RE: Harnett County Land Use Application HTE#07-5-16596

The Harnett County Department of Public Health, Environmental Health Division on July 11, 2007, evaluated the above referenced property at the site designated on the plat/site plan that accompanied your existing tank application. According to your application requesting a 5 bedroom home, the evaluation was done in accordance with the laws and rules governing wastewater systems in North Carolina General Statute 18A.1950 including related statutes and Title 15A, Subchapter 18A, of the North Carolina Administrative Code, Rule.1950 and related rules.

Based on the criteria set out in Title 15A, Subchapter 18A, of the North Carolina Administrative Code, Rules .1950, the evaluation indicated that the site is **UNSUITABLE** for the addition requested. Therefore, your request for an existing tank is **DENIED**. The site is denied based on the following:

Site Plan

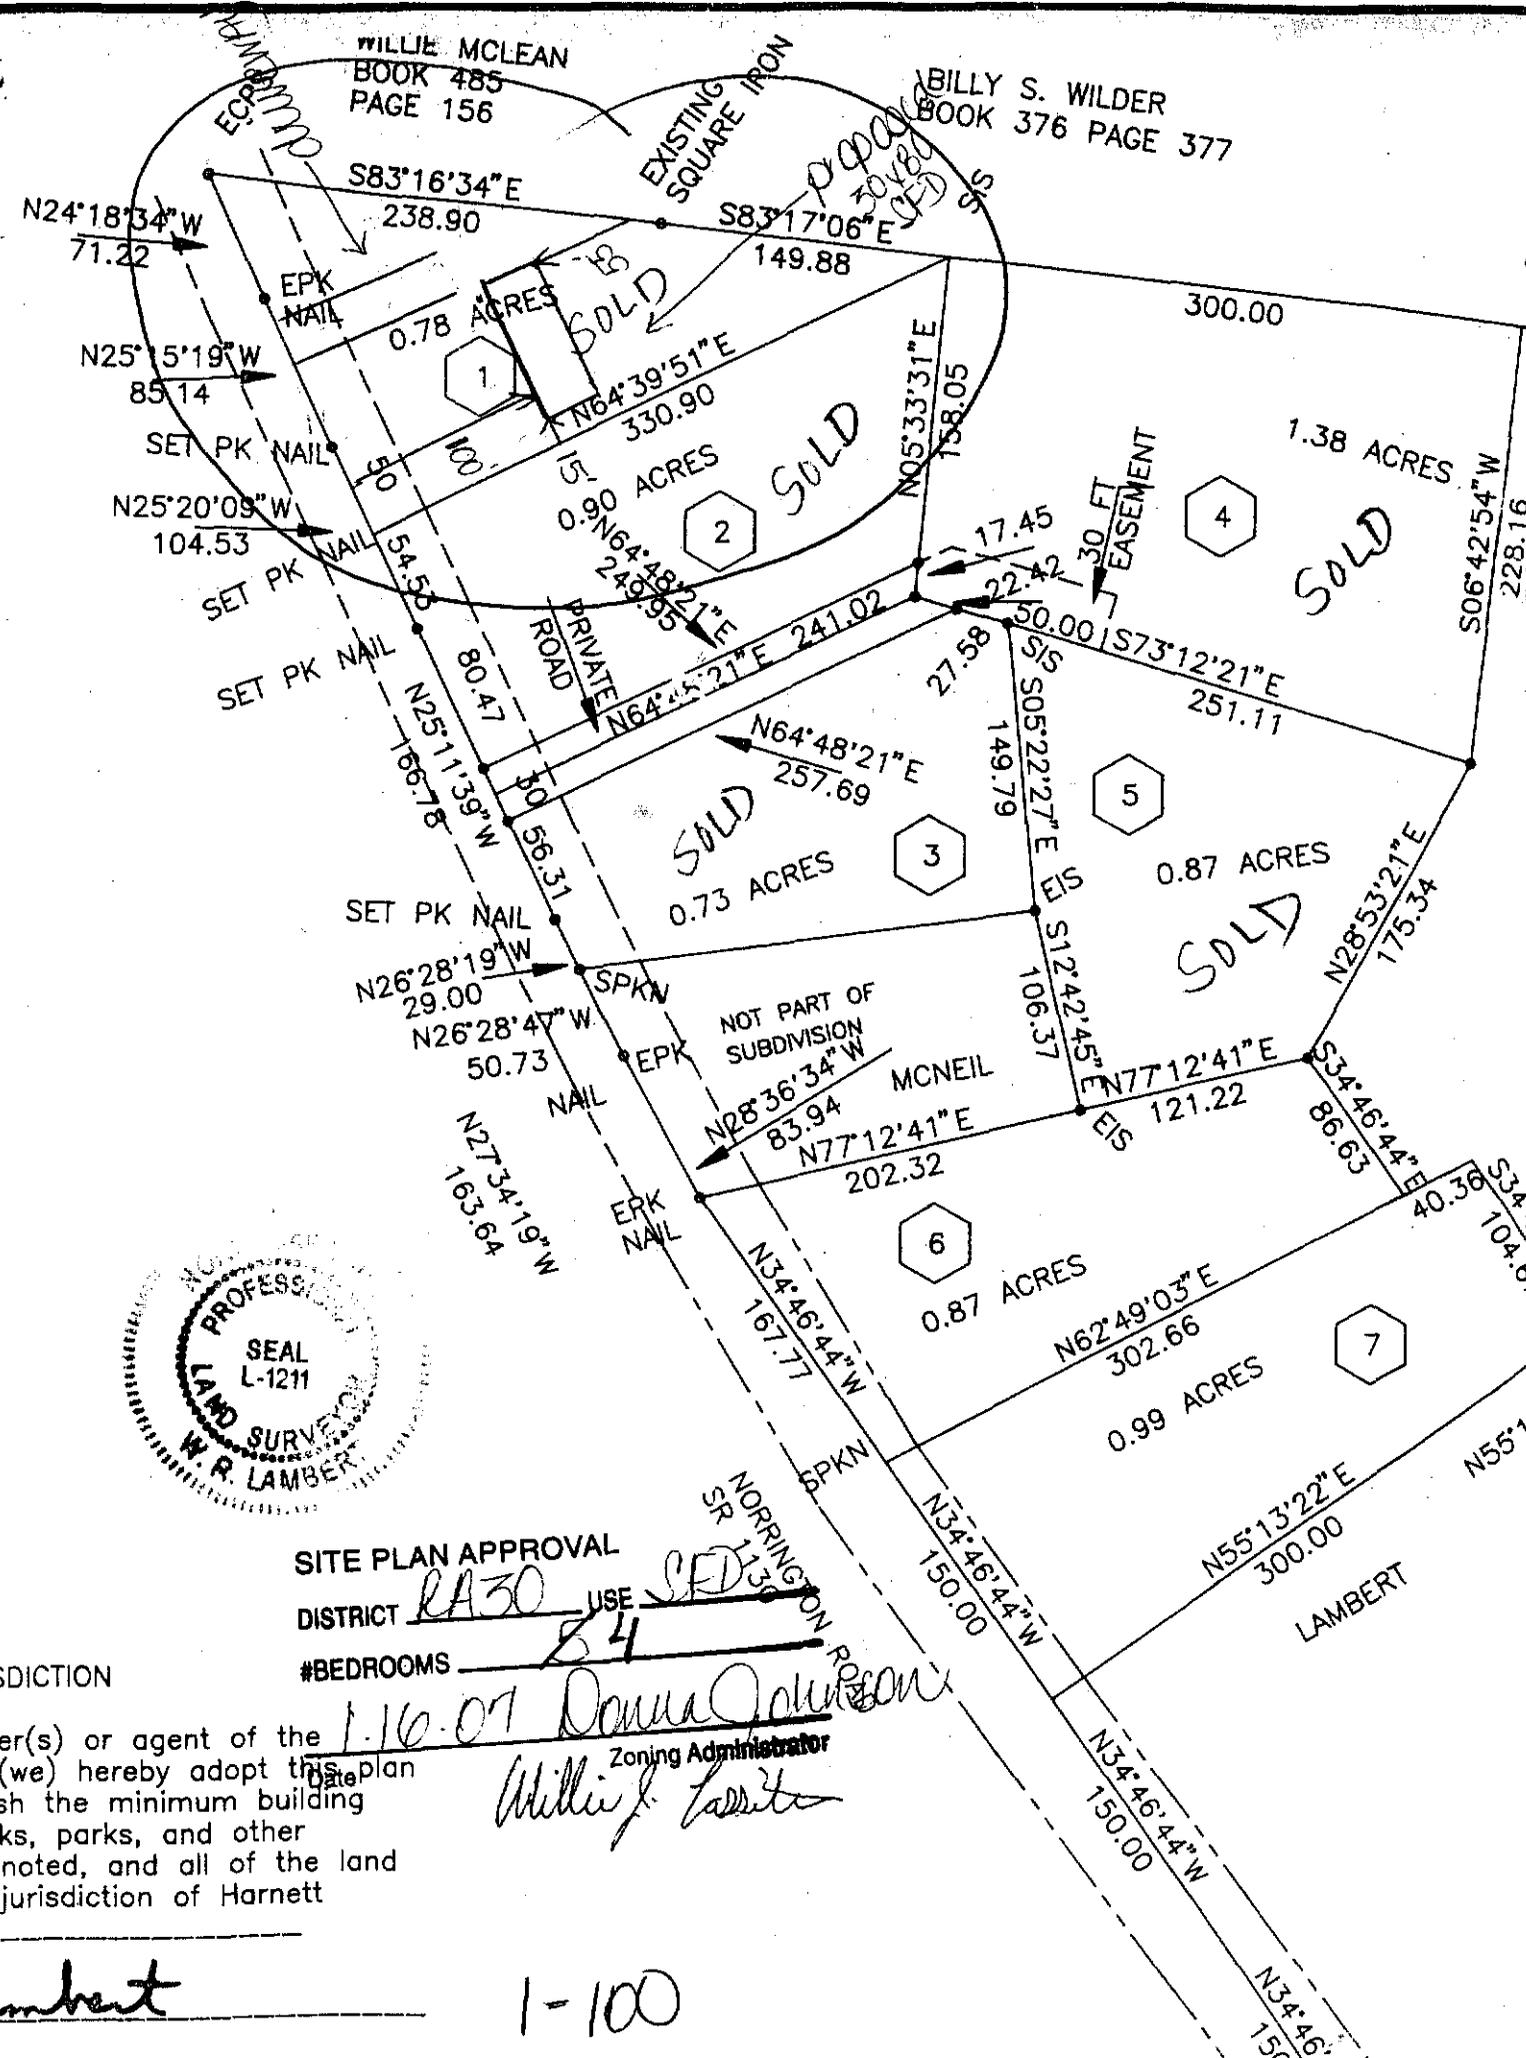
X 15A NCAC 18.1945 (b) Each lot shall have original septic system plus repair area. *Your system is designed for a 3 bedroom home.*
